## **Cactus Creek Ranch Variance of Use - Letter of Intent**

### Summary

# CACTUS CREEK RANCH

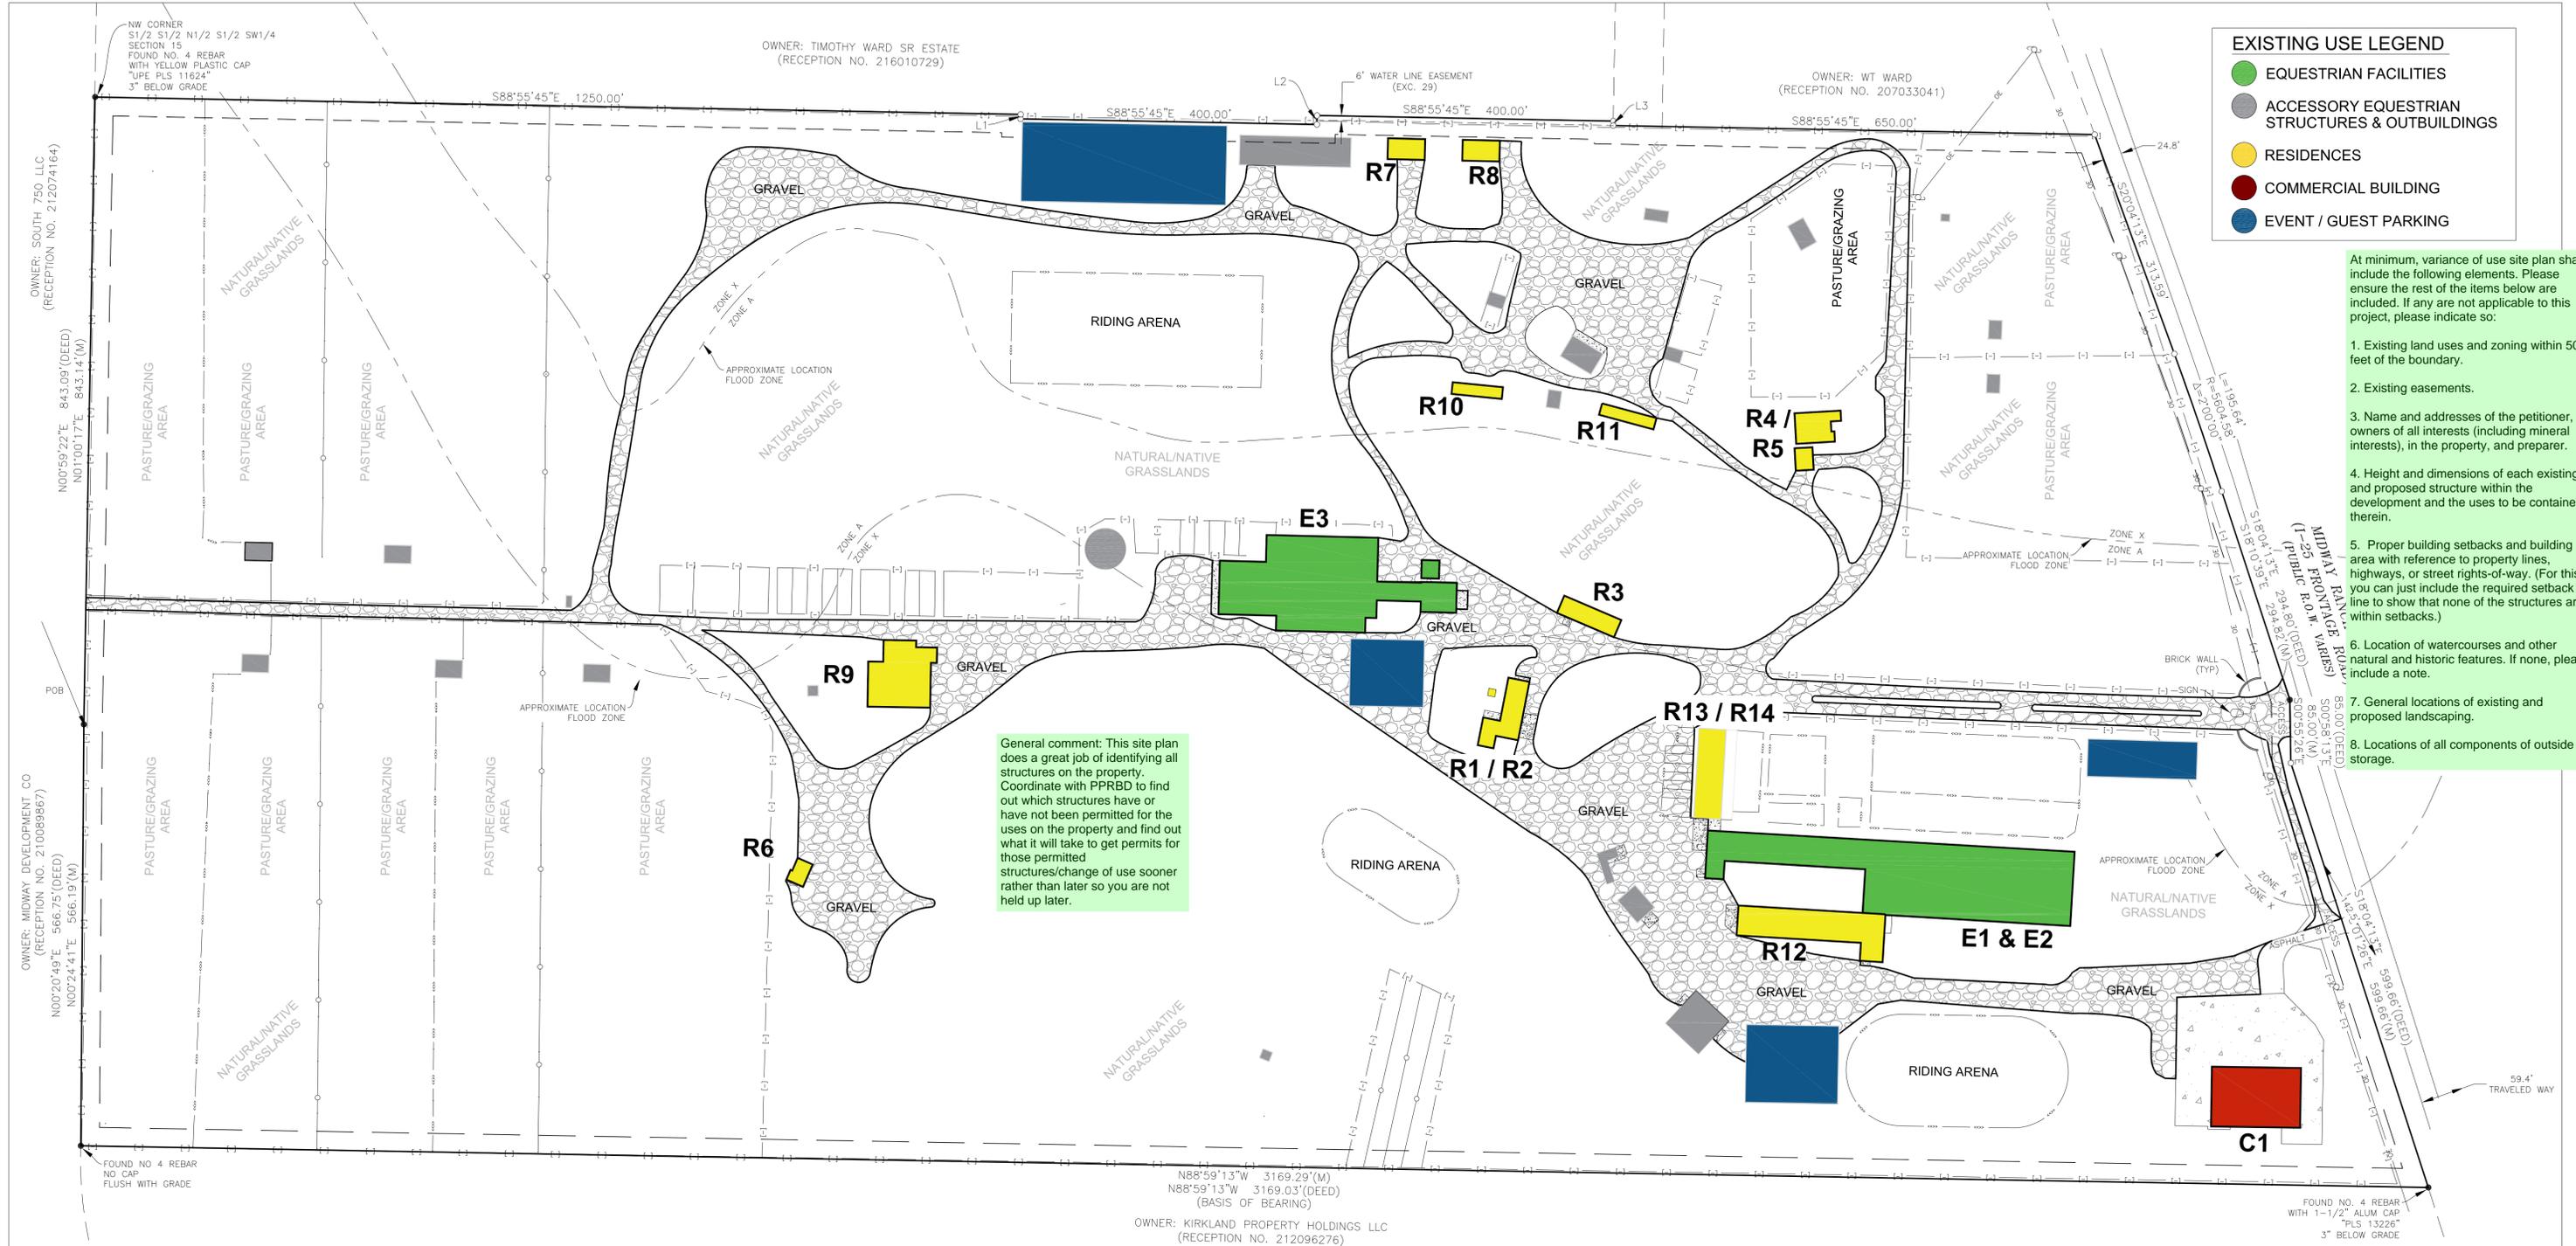
Parking areas on the plan do not indicate number of spaces. Please review the parking restrictions in Sec. 6.2.5 of the LDC and ensure that all uses on the site that have been discussed in this letter have adequate parking facilities.

No landscaping or screening measures have been provided for this site. At a minimum, the commercial uses should be screened from residential uses on and off the property.
